Consultation Response from KC, Highways Development Management		
2021/90540 Queen Street South Car Park, Queen Street South, Huddersfield, HD1 3DH		
Re-configuration of existing car park, erection of charger control building and 5 vehicle charger posts, and gates and railings to boundary		
Date Responded: 22/04/2021	Responding Officer: Zack Turner	Responding Ref: K5-7SE/16

This application is at Queen Street South Car Park, Queen Street South, Huddersfield. The proposal is for the re-configuration of the existing car park, erection of charger control building and 5 vehicle charger posts, and gates and railings to the boundary.

GENERAL ARRANGEMENT
PLAN & ELEVATIONS
PROPOSED

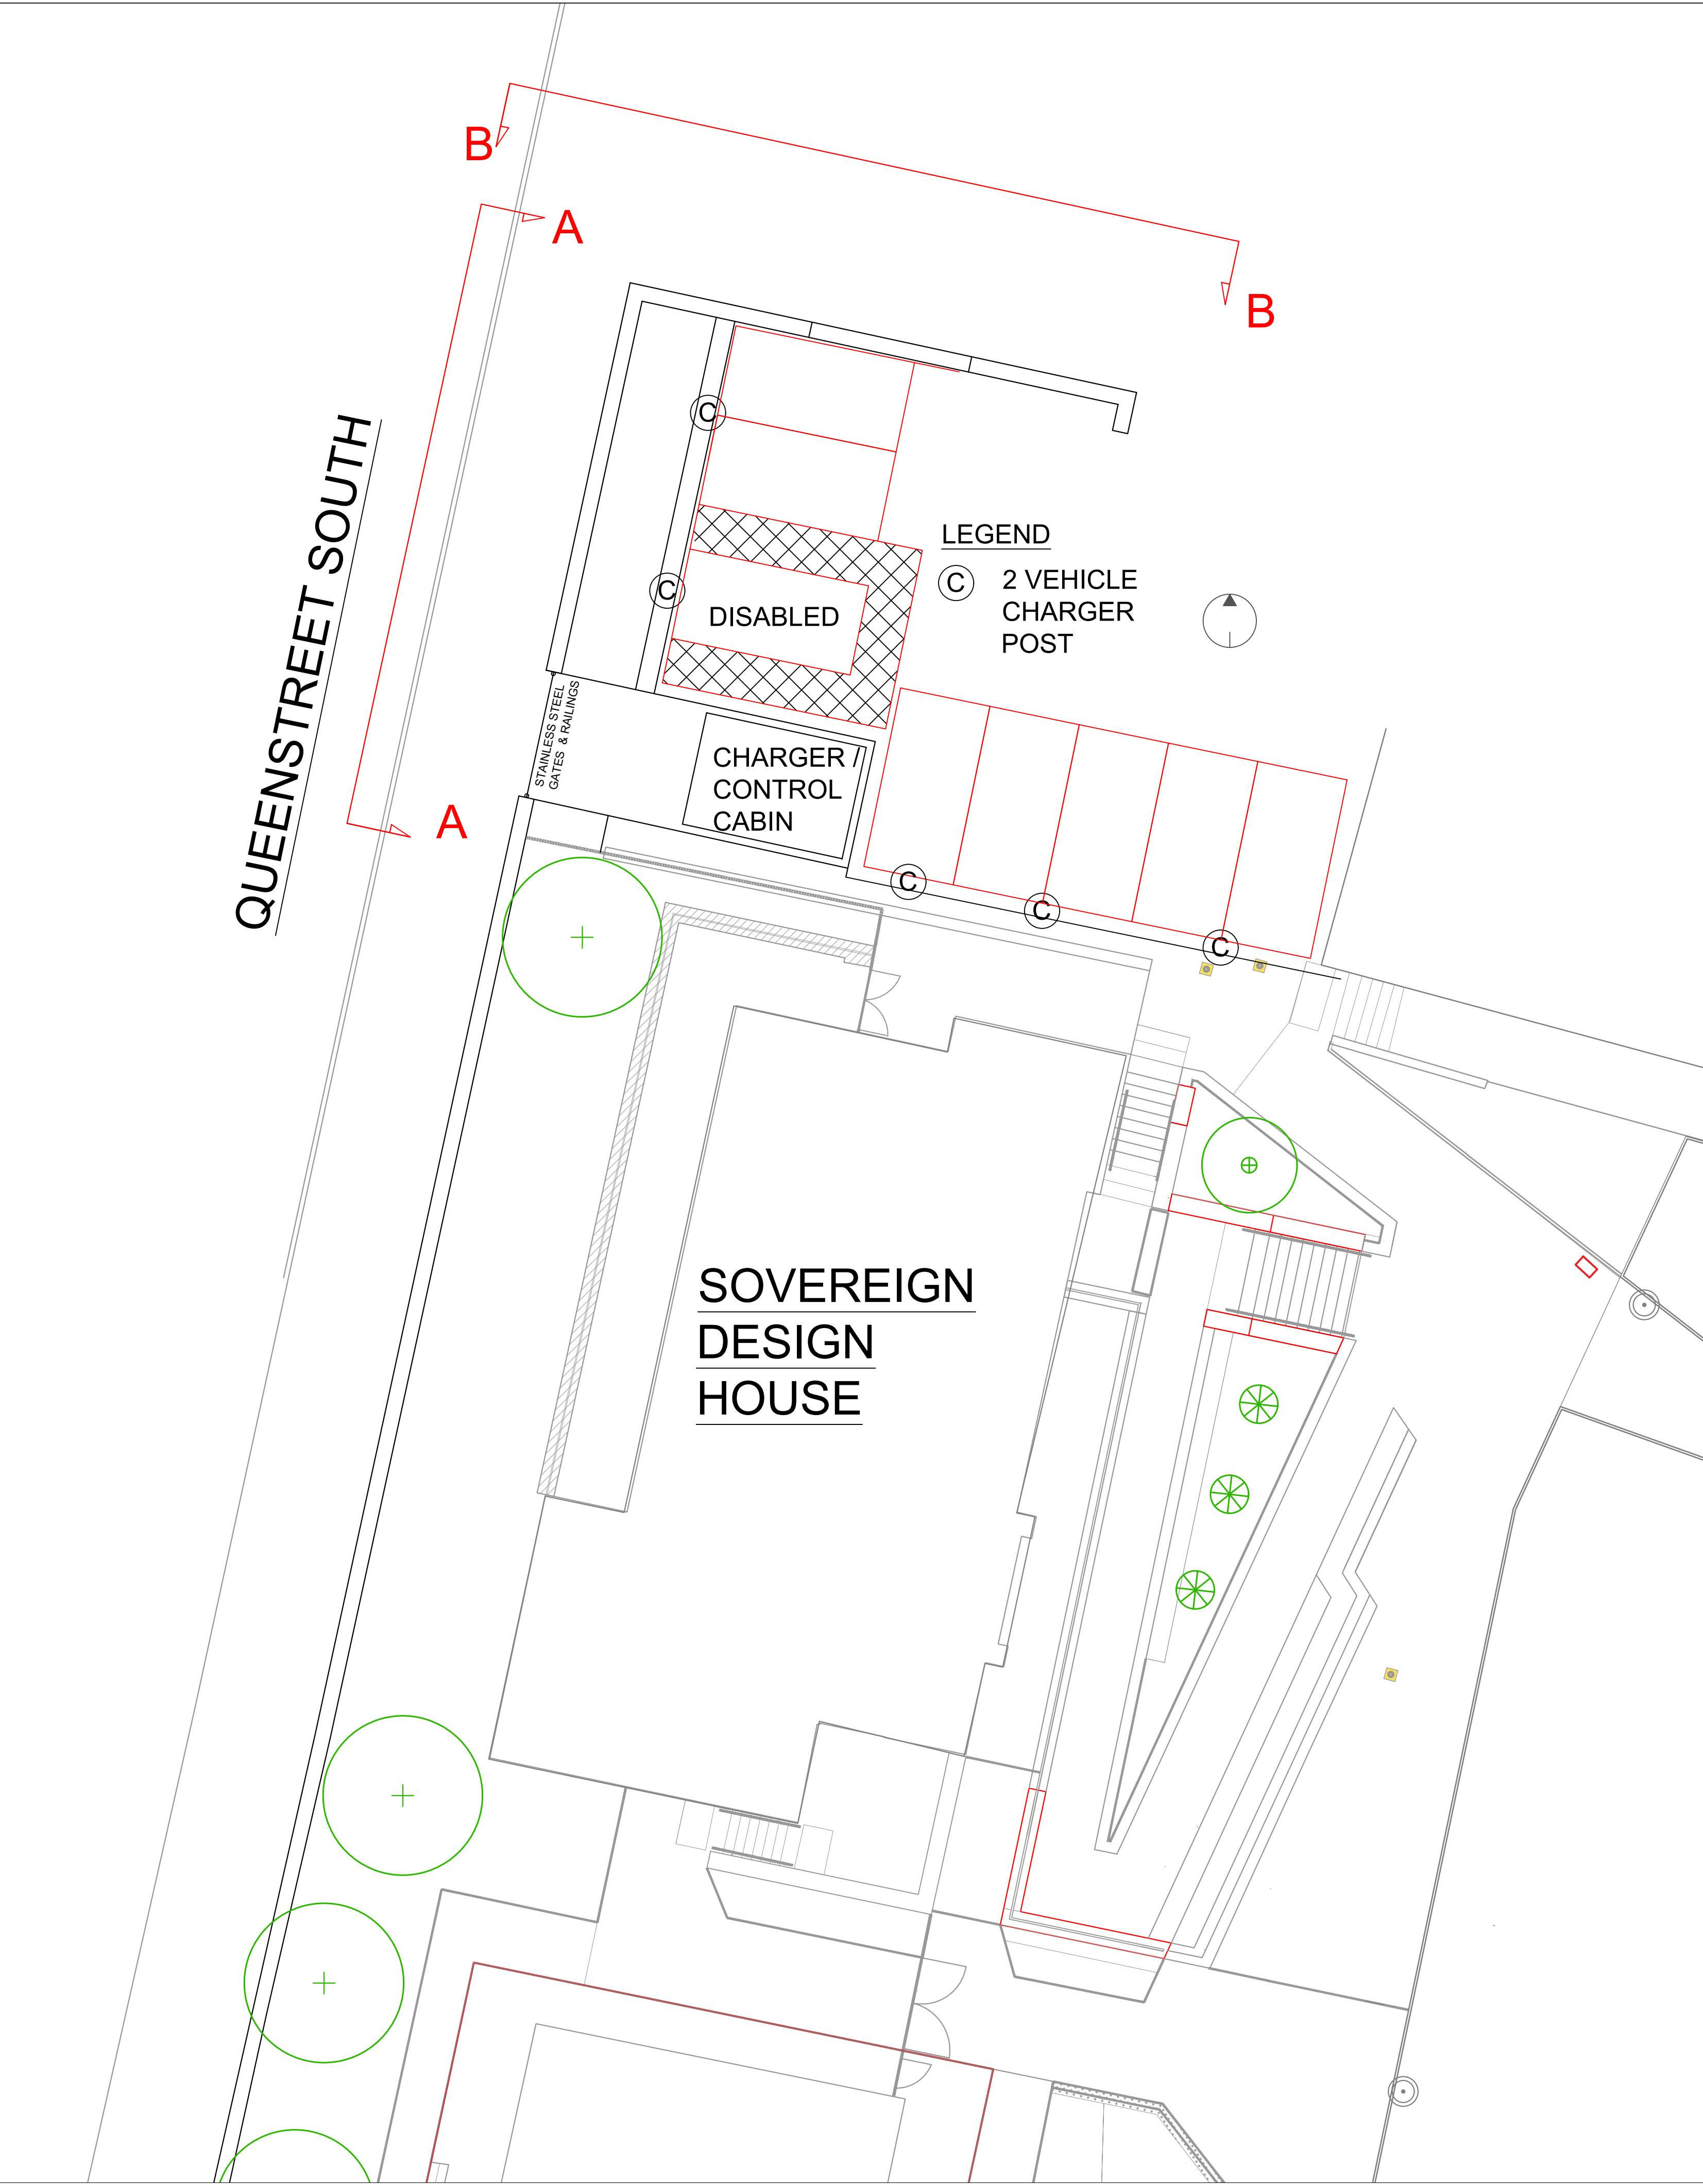
The car park will lose 1 disabled parking space due to the proposals.

Each parking space has the correct dimensions of 2.4m x 4.8m and the disabled parking space has a sufficient 1.2m gap surrounding the space.

All the parking spaces are accessible.
